Your Ref: OWPC14642
Our Ref: A/121/17/HH 21-06-2017
Please ask for:
Mrs A Gardner

Town & Country Planning Act 1990 (as amended)
Town & country Planning (Development Management Procedure) (England) Order 2015

Detached double garage & single storey extensions to existing garage.
Harcourt West Drive Angmering

<table><tr><td>PROJECT HARDCOURT West Drive, Angmering Littlehampton. BN16 4JE</td><td rowspan="4"> 29 Breach Avenue, Southbourne, Emsworth, Hampshire. PO10 8NB T: 01243 697164 M: 07879471666 www.pdkconsulting.co.uk</td><td rowspan="4"> PDK Architecture and Surveying</td></tr><tr><td colspan="2">DRAWING PROPOSED SITE PLAN</td></tr></table>

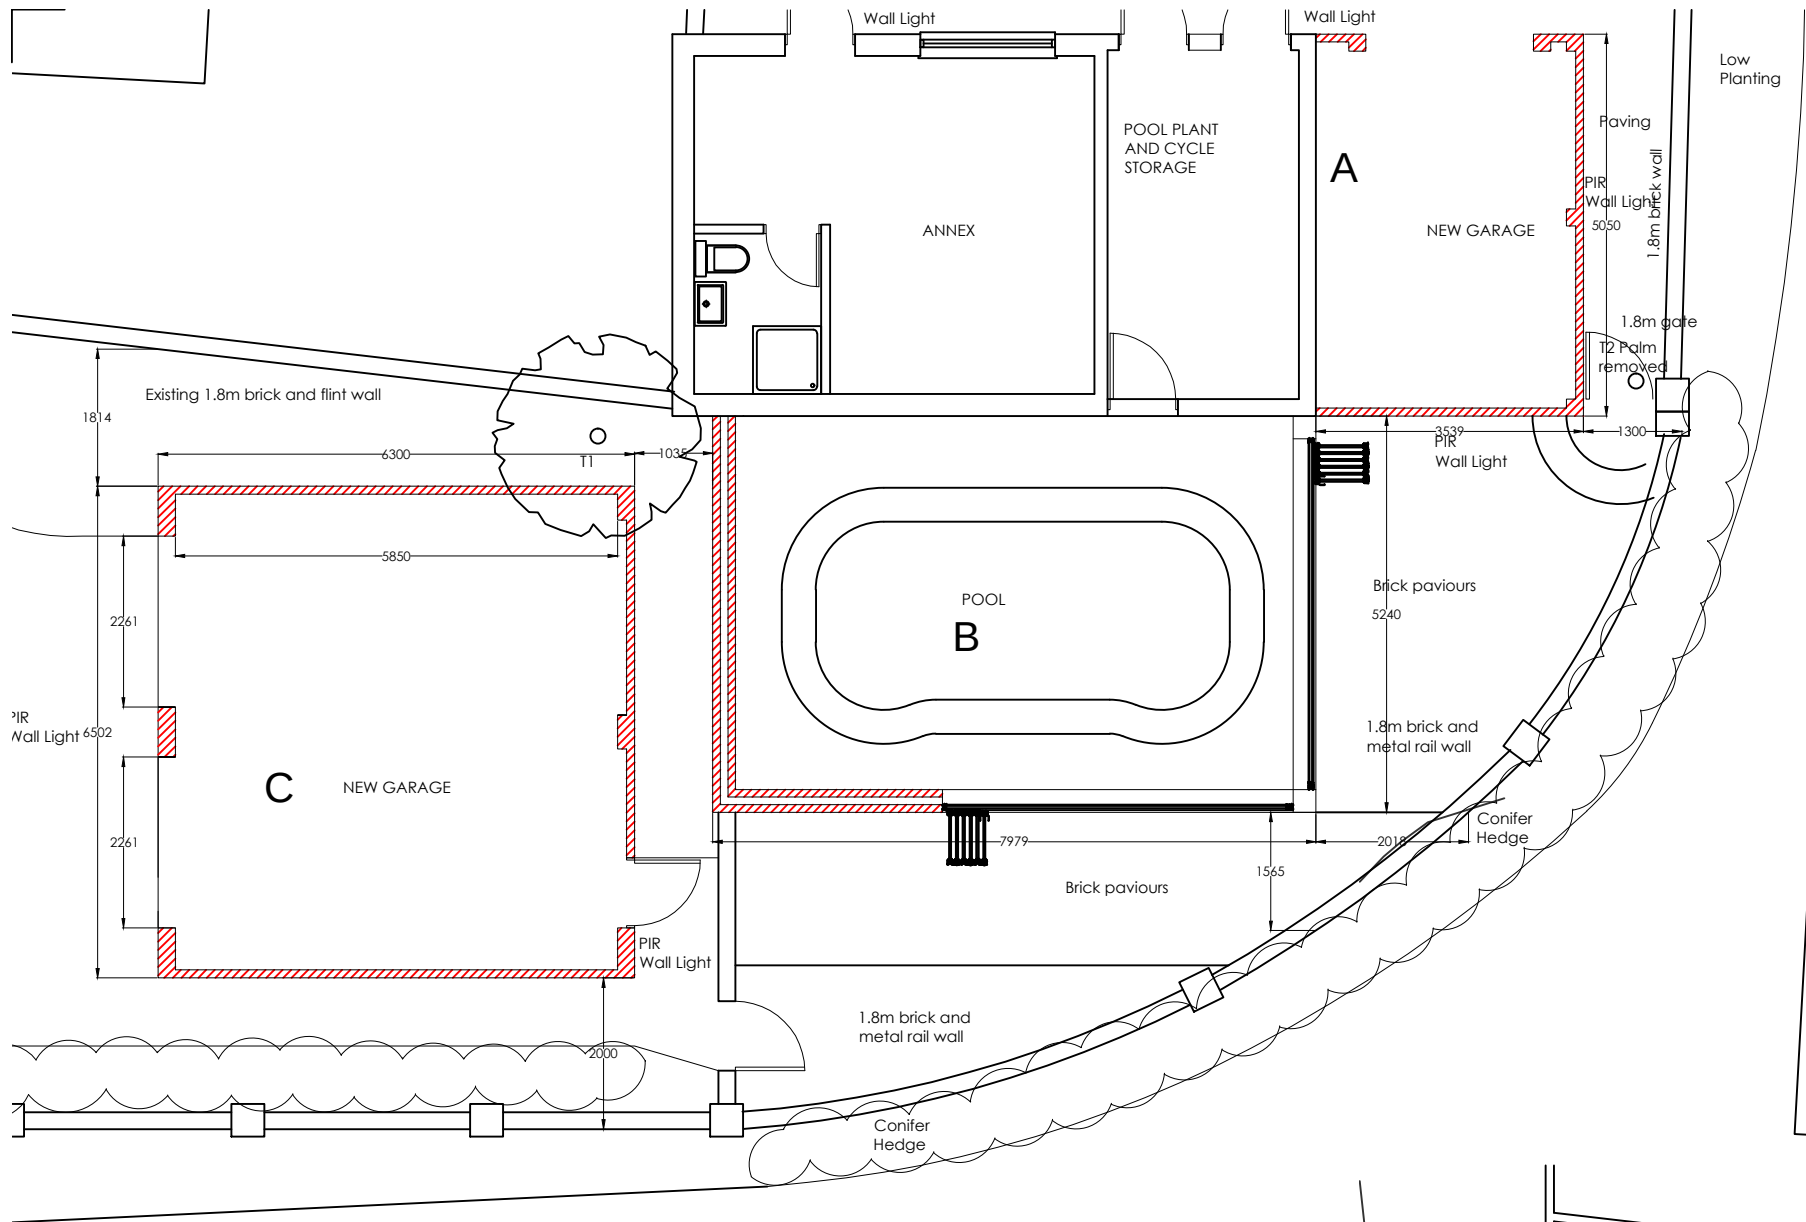
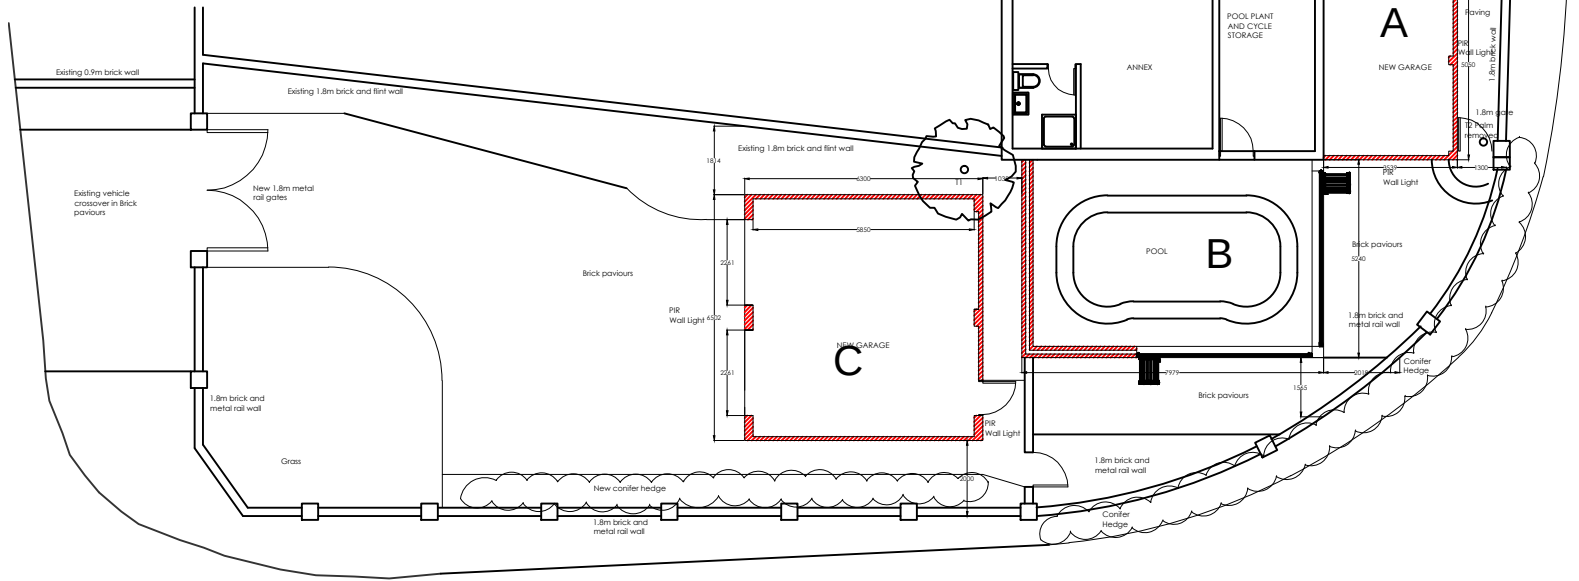
- 1. Entrance to the proposed new garaging is on a particularly dangerous part of West Drive within close proximity to the entrance of Ham Manor Golf Club.*
- 2. Cars exiting from Ham Manor Farm cottages and its neighbours would be subject to restricted view from the north because of the proposed building.*
- 3. On street parking is prevalent in this part of West Drive due to the lack of off street parking for residents in the terraced houses opposite - this proposed development and its access would compromise the safety of road users.*
- 4. Visual amenity would be diminished due to the proximity of the proposed garaging to West Drive.*
